Application by Morgan Offshore Wind Limited and Morecambe Offshore Windfarm Limited for the Morgan and Morecambe Offshore Wind Farms Transmission Assets

The Examining Authority's written questions and requests for information (ExQ1)

Issued on 17 June 2025

**Figure 1.4: Wildlife Hazard Management Zones around Blackpool Airport and Warton Aerodrome**

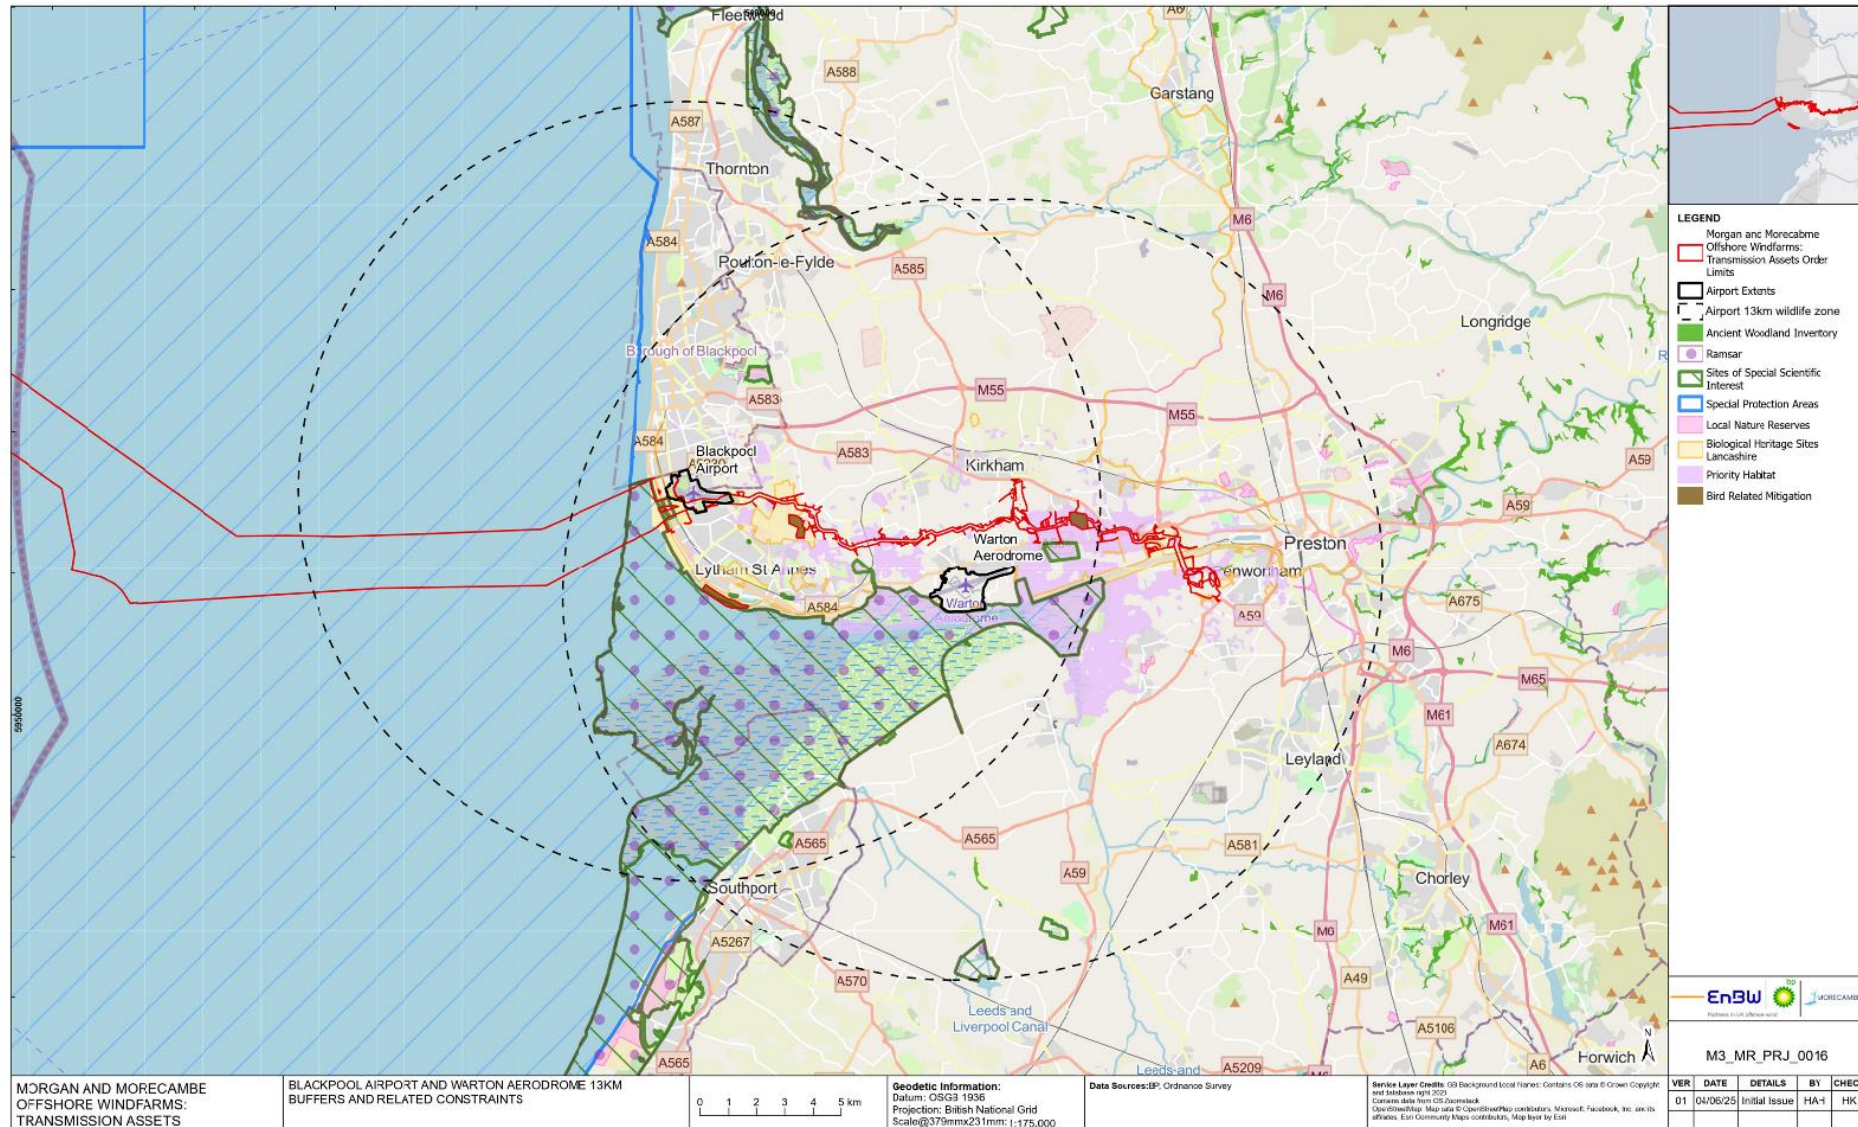
| ExQ1 | Question to: | Question: |
|--------------------------------------------------------------------|---------------------------------------|-----------------------------------------------------------------------------------------------------------------------------------------------------------------------------------------------------------------------------------------------------------------------------------------------------------------------------------------------------------------------------------------------------------------------------------------------------------------------------------------------------------------------------------------------------------------------------------------------------------------------------------------------------------------------------------------------------------------------------------------------------------------------------------------------------------------------------------------------------------------------------------------------------------------------------------------------------------------------------------------------------------------------------------------------------------------------------------------------------------------------------------------------------------------------------------------------------------------------------------------------------------------------------------------------------------------------------------------------------------------------------------------------------------------------------------------------------------------------------------------------------------------------------------------------------------------------------------------------------------|
| Q6.1.15 | NE, EA and any other interested party | <p>Mitigation Paragraph 1.2.1.8 of 'Site Selection of the Environmental Mitigation and Biodiversity Benefit Areas' [REP2-046] states "In accordance, with CAP 772 guidance (Civil Aviation Authority (CAA), 2017) the wildlife hazard management zones around Blackpool Airport and BAE Warton Aerodrome extend to 13 km" and paragraph 1.2.1.9 states "Given the extent of the wildlife hazard management zones in relation to the Transmission Order Limits, the applicants could not locate environmental mitigation and benefit areas</p> |

| ExQ1 | Question to: | Question: |
|------|--------------|------------------------------------------------------------------------------------------------------------------------------------------------------------------------------------------------------------------------------------------------------------------------------------------------------------------------------------------------------------------------------------------------------------------------------------------------------------------------------------------------------------------------------------------------------------------------------------------------------------------------------------------------------------------------------------------------------------------------------------------------------------------------------------------------------------------------------------------------------------------------------------------------------------------------------------------------------------------------------------------------------------------------------------------------------------------------------------------------------------------------------------------------------------------------------------------------------------------------------------------------------------------------------------------------------------------------------------------------------------------------------------------------------------------------------------------------------------------------------------------------------------------------------------------------------------------------------------------------------------------------------------------------------------------------------------------------------------------------------------------------------------------------------------------------------------------------------------------------------------------------------------------------------------------------------------------------------------------------------------------------------------------------------------------------------------------------------------------------------------------------------------------------------------------------------------------------------------------------------------------------------------------------------------------------------------------------------------------------------------------------------------------------------------------------------------------------------------------------------------------------------------------------------------------------------------------------------------------------------------------------------------------------------------------------------------------------------------------------------------------------------------------------------------------------------------------------------------------------------------------------------------------------------------------------------------------------------------------------------------------------------------------------------------------------------------------------------------------------------------------------------------------------------------------------------------------------------------------------------------------------------------------------------------------------------------------------------------------------------------------------------|
| | | <p>outside of the wildlife hazard zones whilst also meeting their site selection guiding principles (as set out in paragraphs 1.2.1.2 and 1.2.1.3) and ultimately delivering effective mitigation.”</p> <p>Paragraph 1.5.1.3 states “The search area also considered areas in proximity to designated habitats or priority habitats, with the objective of improving habitats that are functionally linked to designated sites and improving connectivity between habitats.”</p> <ul style="list-style-type: none"> a) Do you agree that effective mitigation could not be achieved outside wildlife hazard management zones in relation to the Transmission Order Limits? b) Do you agree that biodiversity benefit area objectives would not be met if it was located outside of the wildlife hazard zones? <p>Regarding (a) and the environmental mitigation areas (“EMAs”) – BAE Systems considers that the Applicants’ site selection methodology should take a balanced approach between ecological mitigation objectives and the need to avoid an increased risk of wildlife hazards to aviation interests, including Warton Aerodrome. This requires more than a cursory reference to “<i>site-specific factors</i>” including proximity to aviation infrastructure. Given the potential implications of increased bird strike risk, it requires detailed assessment, the findings of which should be a key driver in the identification of suitable locations for the EMAs, even if this results in less effective (i.e. less than optimal) ecological mitigation. The proximity of aviation infrastructure is not a matter to which an applicant should turn in the “<i>refinement process</i>” (see paragraph 1.2.1.9 of the ‘Site Selection of the Environmental Mitigation and Biodiversity Benefit Areas’ document). The Applicants’ site selection process ought to have considered the area outside of the wildlife hazard safeguarding / management zones around Warton Aerodrome and Blackpool Airport. However, this area appears to have been automatically and arbitrarily discounted as a consequence of the Applicants giving priority (and a disproportionate weighting) to their site selection guiding principles.</p> <p>Regarding (b) and the biodiversity benefit sites (“BBSs”) – BAE Systems understands that the primary objective of the BBSs is to provide a <u>voluntary</u> biodiversity net gain. Therefore, the need to include them within the Transmission Order Limits in order to deliver “<i>effective mitigation</i>” is not understood. Unlike the EMAs, the purpose of the BBSs is not to provide mitigation for the impacts of the authorised development on ecology / biodiversity – the Applicants have conflated the two. The BBSs are intended to provide net gains for biodiversity and, because demonstration of a biodiversity net gain is not mandated for NSIP applications, there are no statutory requirements in relation to the location of these sites. Therefore, the inclusion of the BBSs within the wildlife management zones around Warton Aerodrome and Blackpool Airport, and the Applicants’ decision to discount the area beyond these zones, requires separate and robust justification. As with the EMAs, the same flaw exists in respect of the Applicants’ approach to</p> |

| ExQ1 | Question to: | Question: |
|----------------------------------------|------------------------------------------------------------|---------------------------------------------------------------------------------------------------------------------------------------------------------------------------------------------------------------------------------------------------------------------------------------------------------------------------------------------------------------------------------------------------------------------------------------------------------------------------------------------------------------------------------------------------------------------------------------------------------------------------------------------------------------------------------------------------------------------------------------------------------------------------------------------------------------------------------------------------------------------------------------------------------------------------------------------------------------------------------------------------------------------------------------------------------------------------------------------------------------------------------------------------------------------------------------------------------------------------------------------------------------------------------------------------------------------------------------------------------------------------------------------------------------------------------------------------------------------------------------------------------------------------------------------------------------------------------------------------------------------------------------------------------------------------|
| | | identification of the BBSs – consideration should have been given to the area outside of the wildlife hazard safeguarding / management zones to ensure a balanced approach. However, having regard to the Applicants’ explanation of its site selection process, it’s clear that this area has never been “within scope”. |

**Figure 1.20: Biodiversity Benefit Area at Lea Marsh Fields**

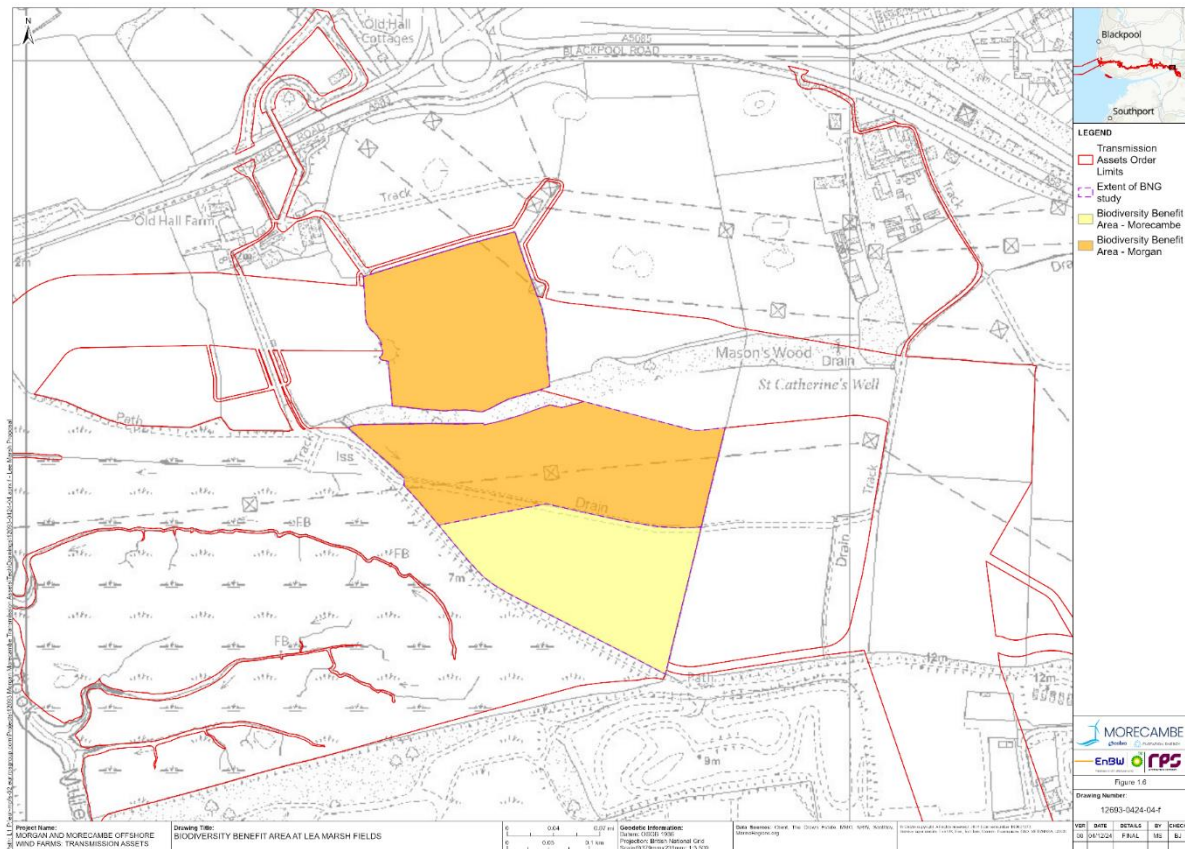
| ExQ1 | Question to: | Question: |
|--------|----------------|-------------------------------------------------------------------------------------------------------------------------------------------------------------------------------------------------------------------------------------------------------------------------------------------------------------------------------------------------------------------------------------------------------------------------------------------------------------------------------------------------------------------------------------------------------------------------------------------------------------------------------------------------------------------------------------------------------------------------------------------------------------------------------------------------------------------------------------------------------------------------------------------------------------------------------------------------------------------------------------------------------------------------------------------------------------------------------------------------------------------------------------------------------------------------------------------------------------------------------------------------------------------------------------------------------------------------------------------------------------------------------------------------------------------------------------------------|
| Q4.1.5 | BAE Systems | <p>Warton Aerodrome In addition to the comments at ISH1, BAE have lodged further comments [REP1-112] and again at D2 [REP2-052] emphasising the need and scope for a bird strike assessment at this stage. There is a particular concern over the creation of the biodiversity area at Lea Marsh Fields and BAE do not believe that mitigation strategies are appropriate until there is a better understanding of the possible bird strike risk. In view of the latest response from the applicants [REP1-037], is BAE any closer to undertaking an assessment?</p> <p>As detailed in the response to Q4.1.3 above, the Applicant is the party responsible for undertaking any bird strike risk assessment. The Applicants have prepared a “Strategy for Wildlife Hazard Management Plan” (submitted to the examination at Deadline 2 – Examination Library Document Ref: REP2-047). This sets out the Applicants’ approach to / proposed scope for assessing current bird populations and how they move around the area, as well as briefly describing how the Applicants propose to mitigate any increase in the risk to operations at Warton Aerodrome. BAE Systems welcomes this; however, the scope of the outline WHMP does not include any assessment of how the existing / baseline bird strike risk may be altered by the introduction of the proposed environmental mitigation areas and biodiversity benefit sites.</p> |

| ExQ1 | Question to: | Question: |
|------|--------------|-----------------------------------------------------------------------------------------------------------------------------------------------------------------------------------------------------------------------------------------------------------------------------------------------------------------------------------------------------------------------------------------------------------------------------------------------------------------------------------------------------------------------------------------------------------------------------------------------------------------------------------------------------------------------------------------------------------------------------------------------------------------------------------------------------------------------------------------------------------------------------------------------------------------------------------------------------------------------------------------------------------------------------------------------------------------------------------------------------------------------------------------------------------------------------------------------------------------------------------------------------------------------------------------------------------------------------------------------------------------------------------------------------------------------------------------------------------------------------------------------------------------------------------------------------------------------------------------------------------------------------------------------------------------------------------------------------------------------------------------------------------------------------------------------------------------------------------------------------------------------------------------------------------------------------------------------------------------------------------------------------------------------------------------------------------------------------------------------------------------------------------------------------------------------------------------------------------------------------------------------------------------------------------------------------------------------------------------------------------------------------------------|
| | | <p>As BAE Systems has repeatedly stated, it is essential that the Applicants undertake a bird strike risk assessment in order to identify potential changes in bird numbers, concentrations, and movement / migration patterns which may be precipitated by the authorised development and the resultant risk posed to operations at Warton Aerodrome. The results of this assessment can then sensibly inform a discussion in respect of mitigation and the appropriate measures which are required to be implemented in order to address any adverse operational outcomes.</p> <p>BAE Systems is willing to work with the Applicants and to provide them with what information it can in order to enable the Applicants to undertake a bird strike risk assessment and to develop a detailed WHMP and any other appropriate mitigation / management measures which may be required. However, as stated in the response to Q4.1.3 above, an NDA is required to be put in place as a pre-condition to any information sharing.</p> <p>Will this be required by the Civil Aviation Authority?</p> <p>BAE Systems currently manages wildlife hazard risk within the 13km wildlife safeguarding zone around Warton Aerodrome. Under the terms of its licence, BAE Systems is required to demonstrate to the Civil Aviation Authority (“CAA”) that it is adequately managing risk. To do so, it must provide the CAA with the following information:</p> <ul style="list-style-type: none"> • a 13km aerodrome wildlife survey; • a Wildlife and Habitat Hazard Management Plan; • a Term Safety Plan (which includes a bird strike risk assessment); and • a Strike Rate Probability Index, which tracks and monitors bird strikes and assesses risk to Warton Aerodrome. <p>BAE Systems is required to keep the above-mentioned information under review. The documents listed will require updating to consider the “post-development risk” arising from the authorised development and BAE Systems will be reliant upon the provision of sufficient information from the Applicants to complete the required updates.</p> <p>BAE Systems will need to be satisfied that the “post-development risk” arising from the authorised development is capable of being appropriately mitigated in order that it can discharge its duty under the</p> |
